MEMORANDUM

TO: Jean Fraser, Planner
FROM: David Senus, P.E. & Ashley Auger, E.I.T.
DATE: March 3, 2014
RE: 421 Warren Avenue, Preliminary Level III Site Plan Application

- Preliminary Level III Site Plan Application and attachments dated February 12, 2014, prepared by FST Engineers on behalf of PH Warren Avenue, LLC.
- Engineering Plans, Sheets C-1.0, C-1.1, C-2.0, C-2.1, C-3.0, C-3.1, C-4.0, C-4.1, C-4.2, C-4.3, C-5.0, C-6.0, C-6.1, C-6.2, C-7.0, and C-7.1, dated February 10, 2014, prepared by FST Engineers on behalf of PH Warren Avenue, LLC.

I GRAVEL WETLAND #2 FLOW CONTROL PANEL WEIR SECTION
N.T.S. (SEE DETAIL 'C' ON SHEET C-6.2 FOR WALL ELEVATION DETAIL)

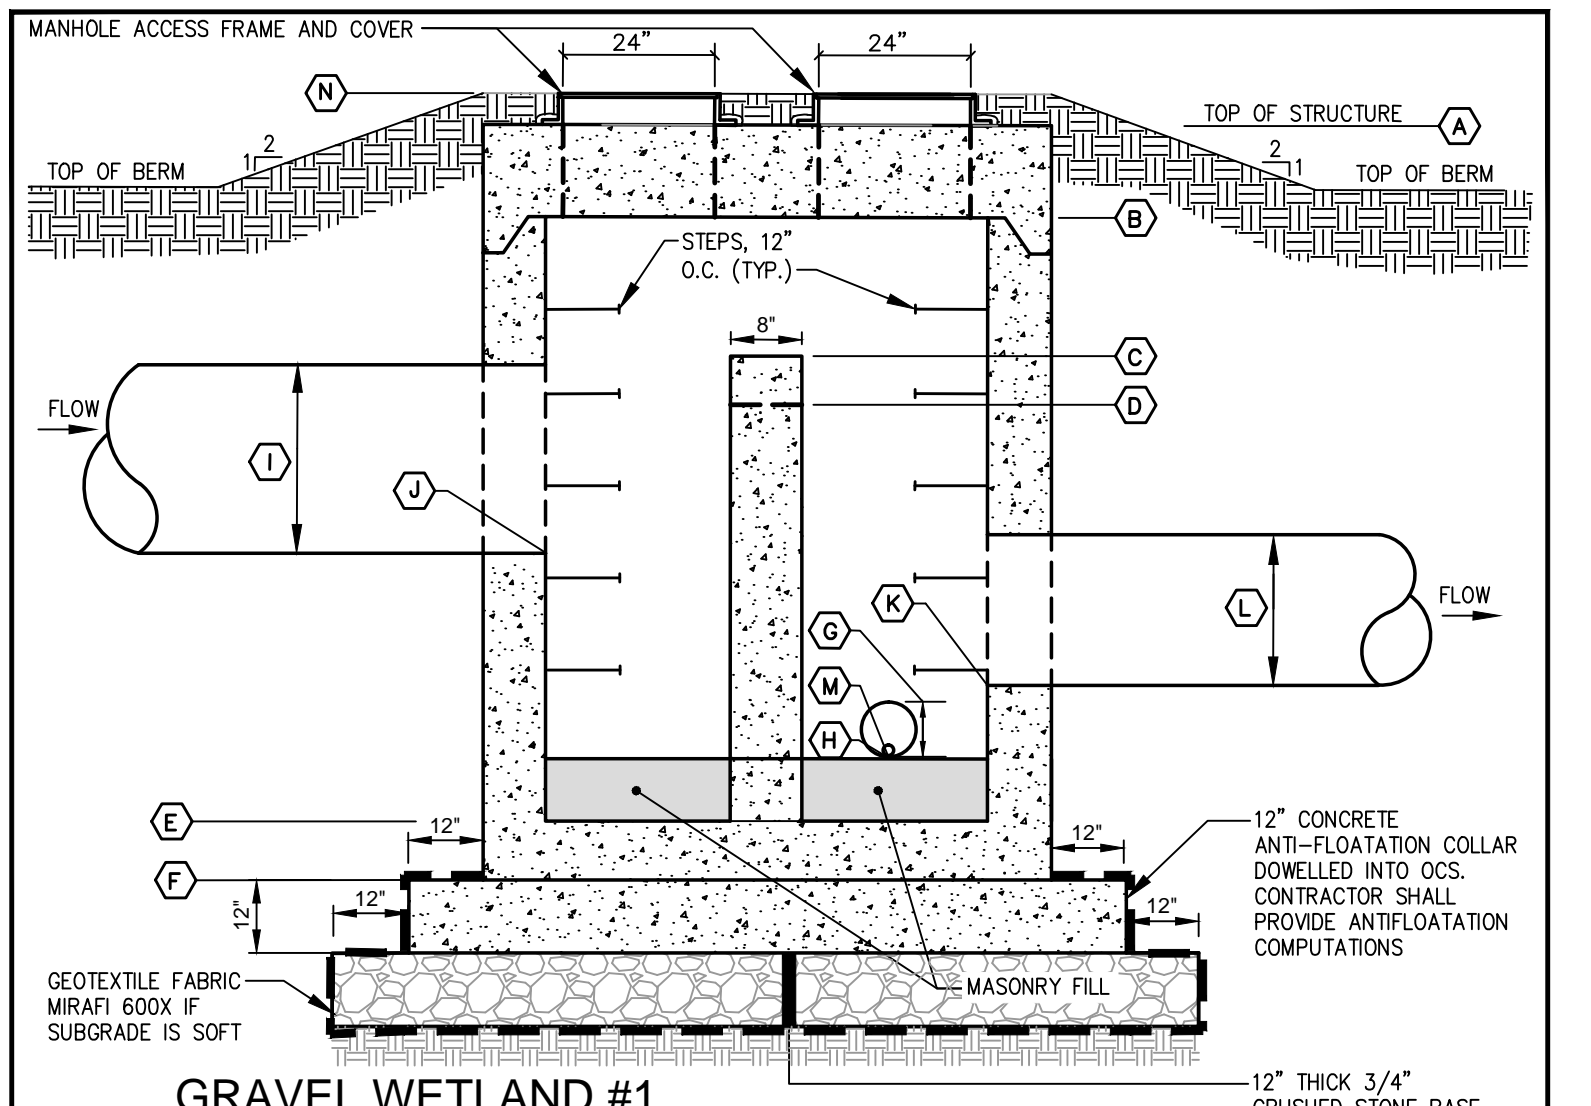
- e) As noted on the plans, the Applicant intends to add outlet elevation information to the outlet control structure details for both gravel wetlands as part of the final submittal. Without this information we cannot verify the routing or model inputs for Pond 4P (GW2) or Pond 5P (GW1). When the outlet control structure elevations are incorporated into the final submittal, please revisit or provide explanation on the routing methodology for GW1 & GW2 in the HydroCAD model; we are unable to follow the routing as currently presented.

- b) The Applicant has submitted drawdown calculations for sizing the gravel wetlands' outlet control structure orifice control devices; however, the orifices do not appear to be specified on the design plans/details. The Applicant should clarify with the final design package.
